Application Reference: EN010115
ESC Reference: ESC Relevant Representation –
Five Estuaries Offshore Wind
Farm Project
Date: 19/06/2024
Please ask for: [REDACTED]
Customer Services: 03330 162 000
Direct dial: [REDACTED] 45
Email: [REDACTED]@eastsoffolk.gov.uk

Re: Application by Five Estuaries Offshore Wind Farm Limited for an Order Granting Development Consent for the Five Estuaries Offshore Wind Farm Project – East Suffolk Council’s Relevant Representation.

Figure 10.34c  
 Viewpoint 9: Orfordness (Roof - Bomb Ballistics Building)  
 Five Estuaries

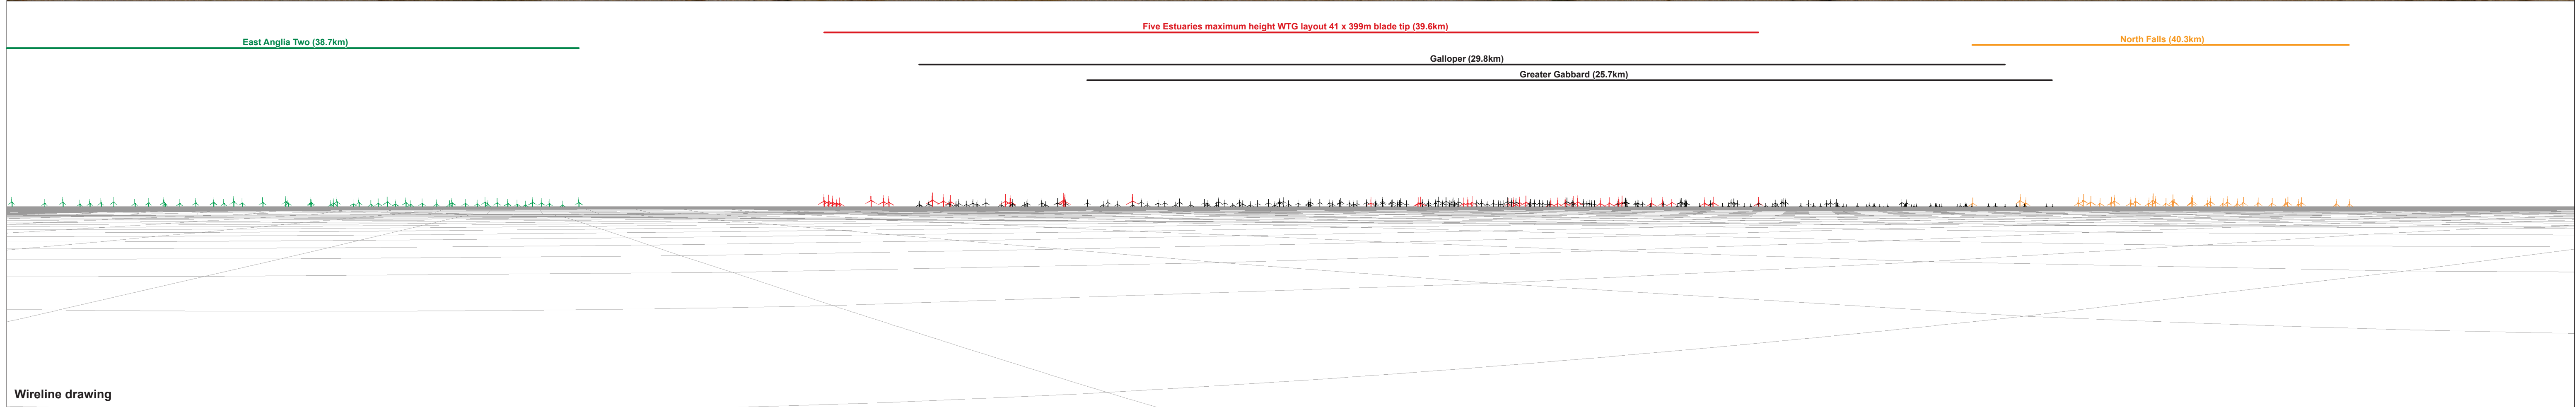
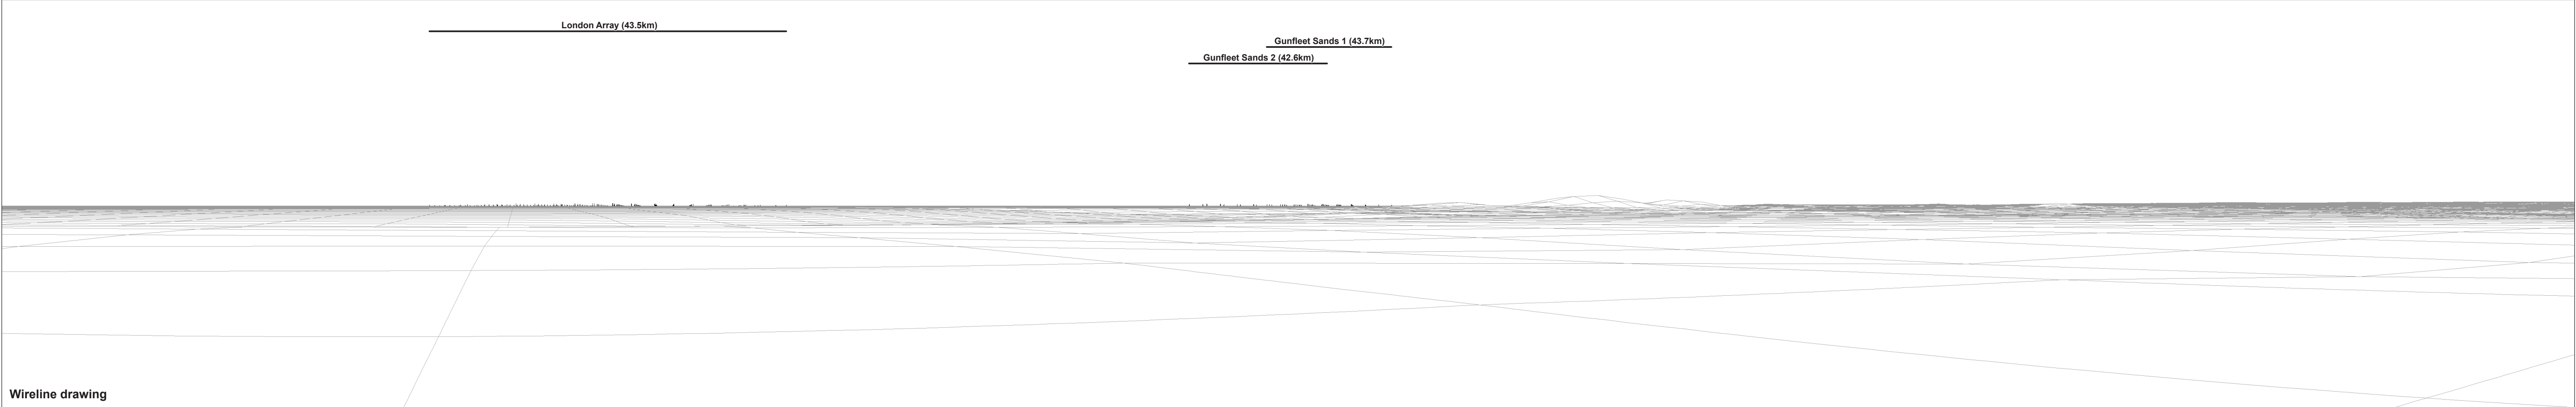
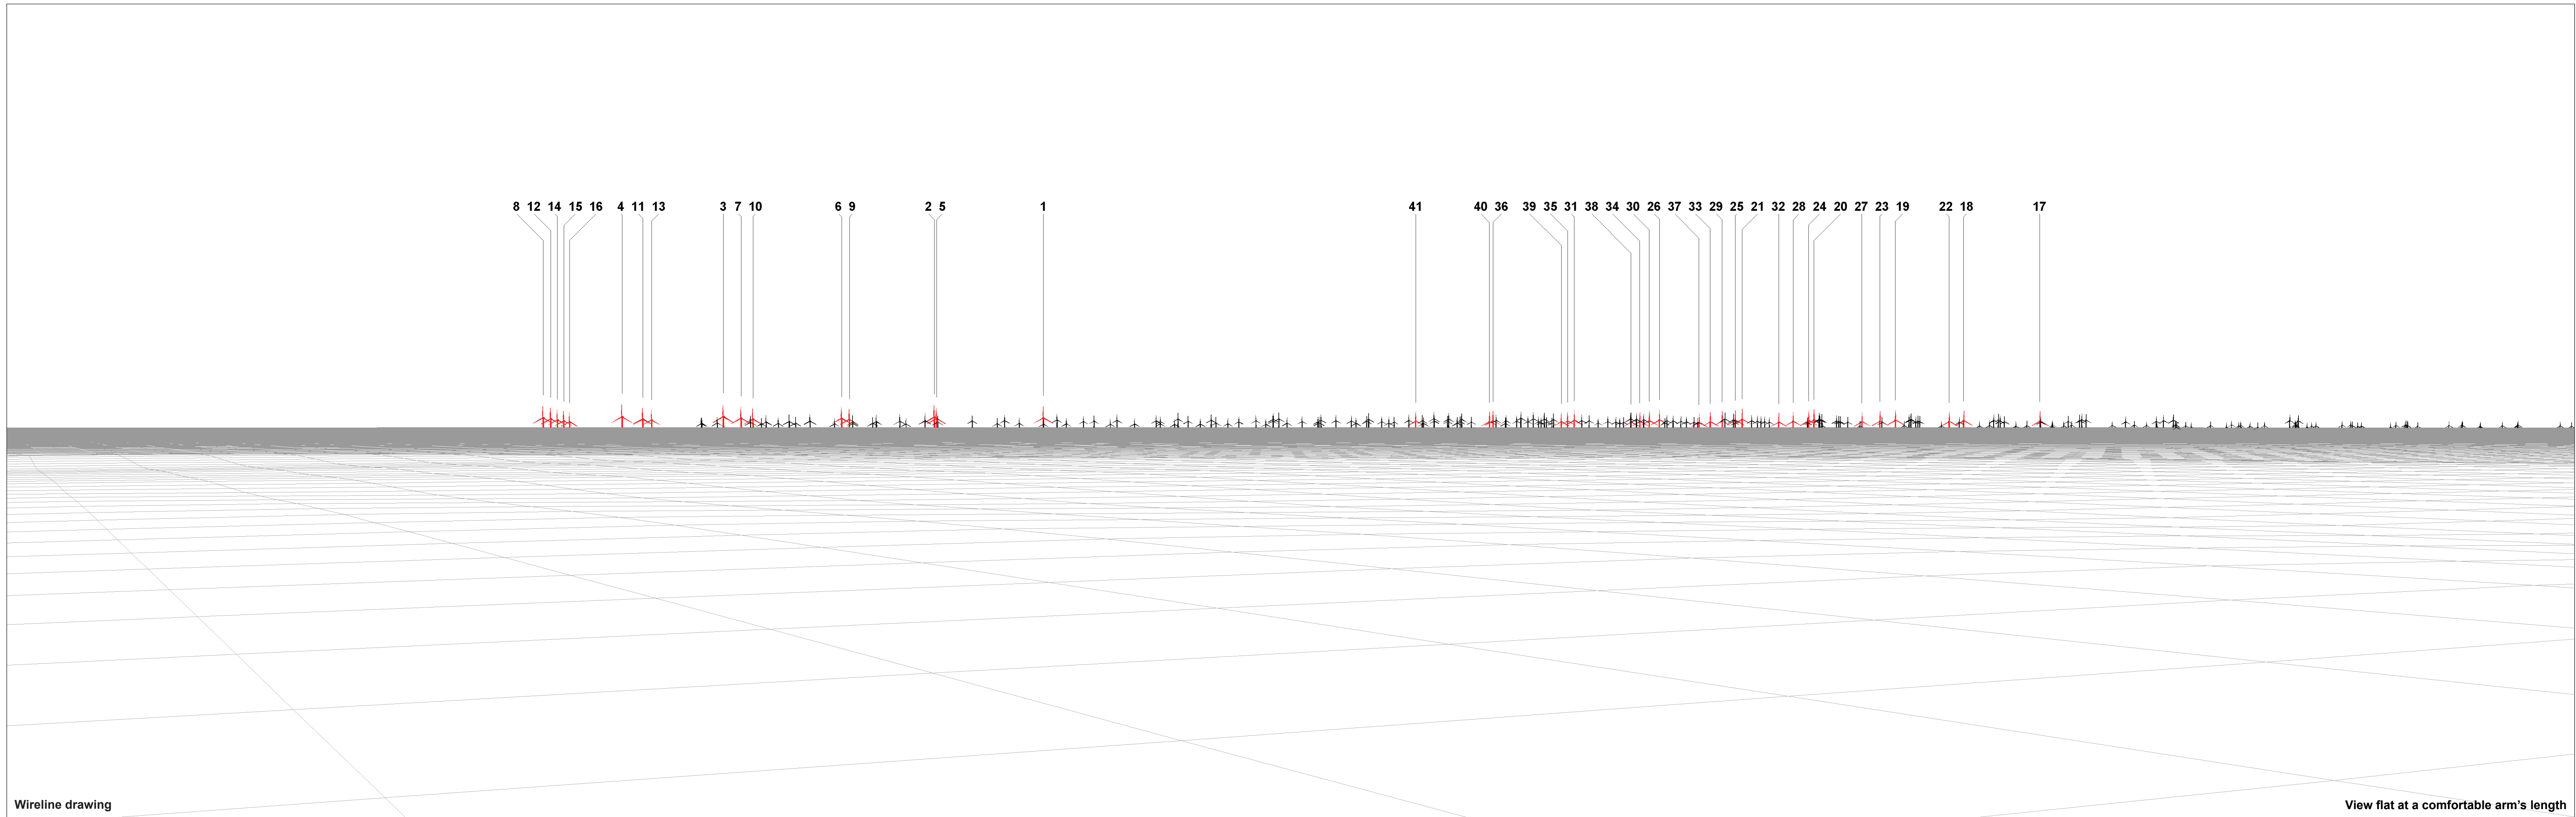
Galloper/Gabbard windfarm groups. The range of distances from the various viewpoints to the nearest point of the proposed windfarm is from 38.2km (Orford Ness Bomb Ballistics Building VP9) to 49km (Felixstowe Old Town VP11). These distances are a key component in understanding the likely visibility frequency of the turbines throughout the year. Taking account of known Meteorological Office data, in the case of VP11 at 49km, the visibility frequency likelihood is 8.9%. For VP9 at 38.2km, the frequency is 20.9%. This is the full extent of the range of visibility frequency i.e. 8.9%-20.9%.

For many of the East Suffolk viewpoints, the new turbines will be aligned behind the existing Galloper / Gabbard windfarms from the perspective of the observer, also being more distant from the shore. Despite the new wind turbines being significantly taller structures than the existing wind farms, they will only be seen as having slightly greater stature. The ESC Principal landscape officer has experienced views of the Galloper / Gabbard cluster from several of the East Suffolk viewpoints on numerous occasions, and notes that due to weather conditions and distance, it is often more likely that they will not be highly visible on the horizon. ESC therefore accepts that the conclusions set out within the Applicant's submitted assessment are realistic and acceptably reliable.
